Response to Planning application from Hertfordshire County Council (T and CP GDP Order 2015)

District ref: 6/2020/3451/MAJ
HCC ref: WH/5158/2021
HCC received: 11 January 2021
Area manager: Matthew Armstrong
Case officer: Samuel Tearle

WELLS FARM NORTHAW ROAD EAST CUFFLEY POTTERS BAR EN6 4RD

Demolition of existing buildings and erection of 14 dwellings

JOB NO:	DRAWING NO:	REVISION:
1911-066	PL03	C

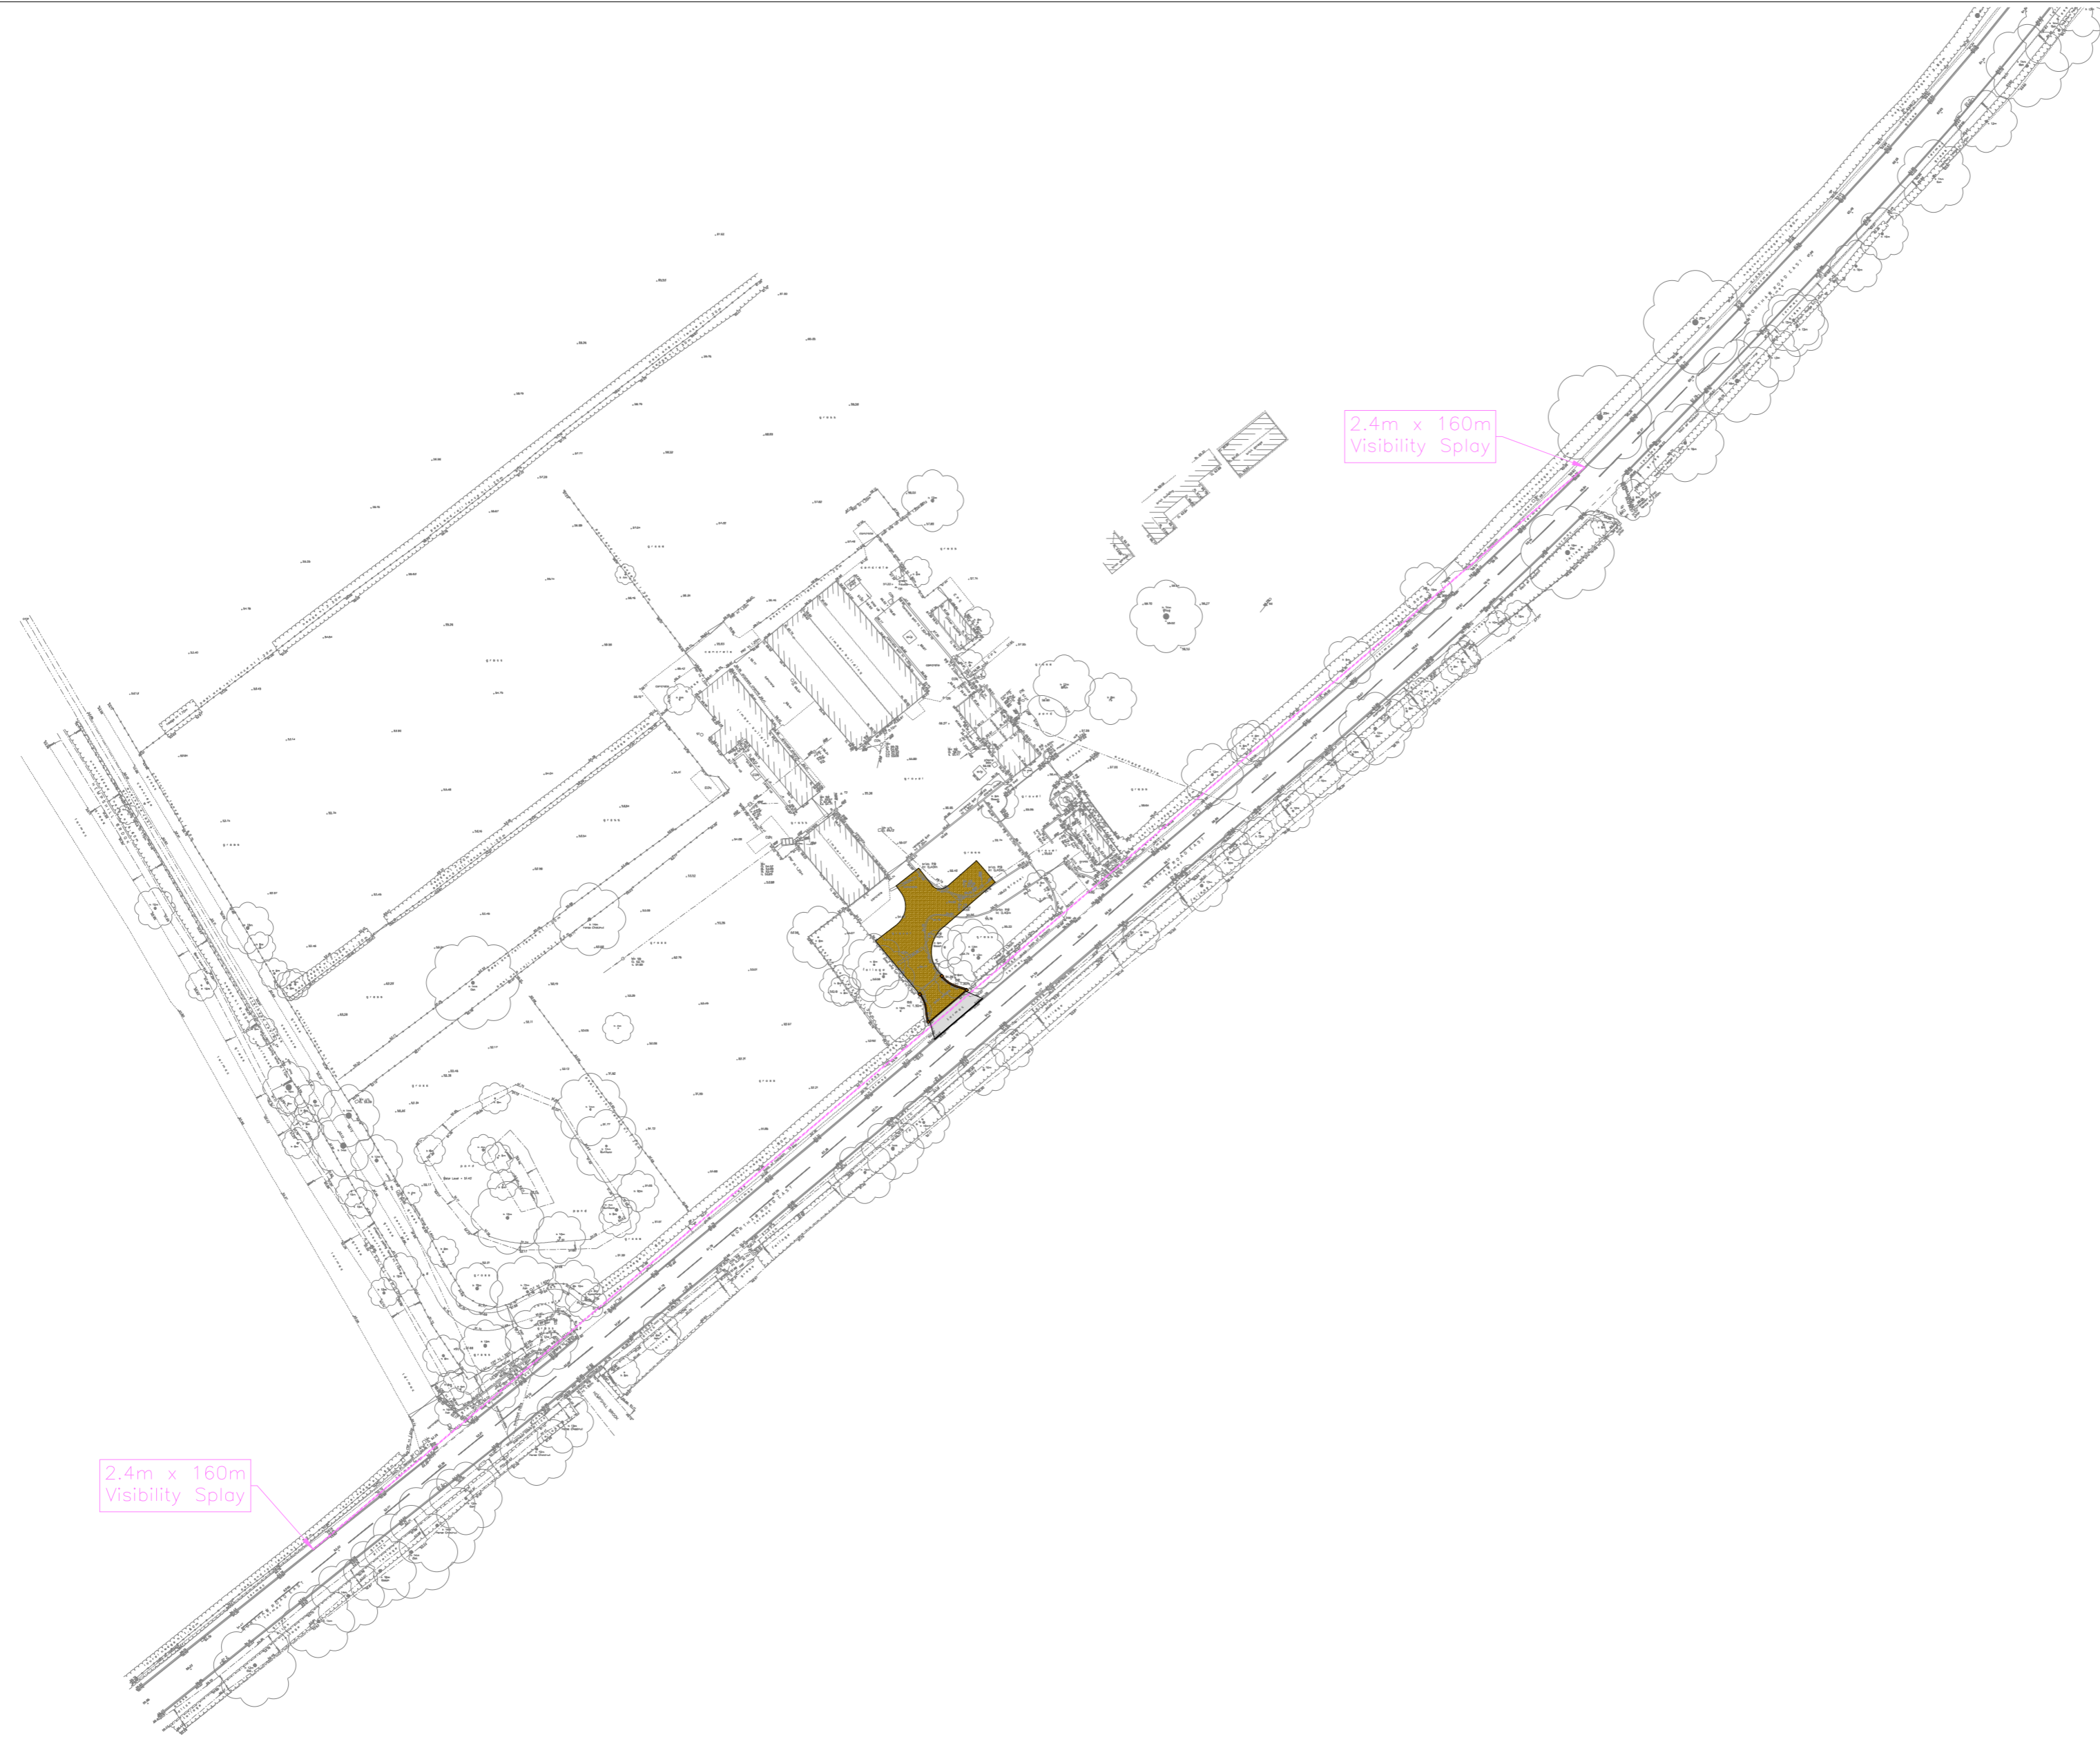
A visibility splay drawing (Drawing No. PL03) has been submitted for the access which shows visibility of 2.4m x 160m, which is not considered suitable for national speed limit or the standards contained in the DMRB/Road in Hertfordshire: Highways Design Guide.
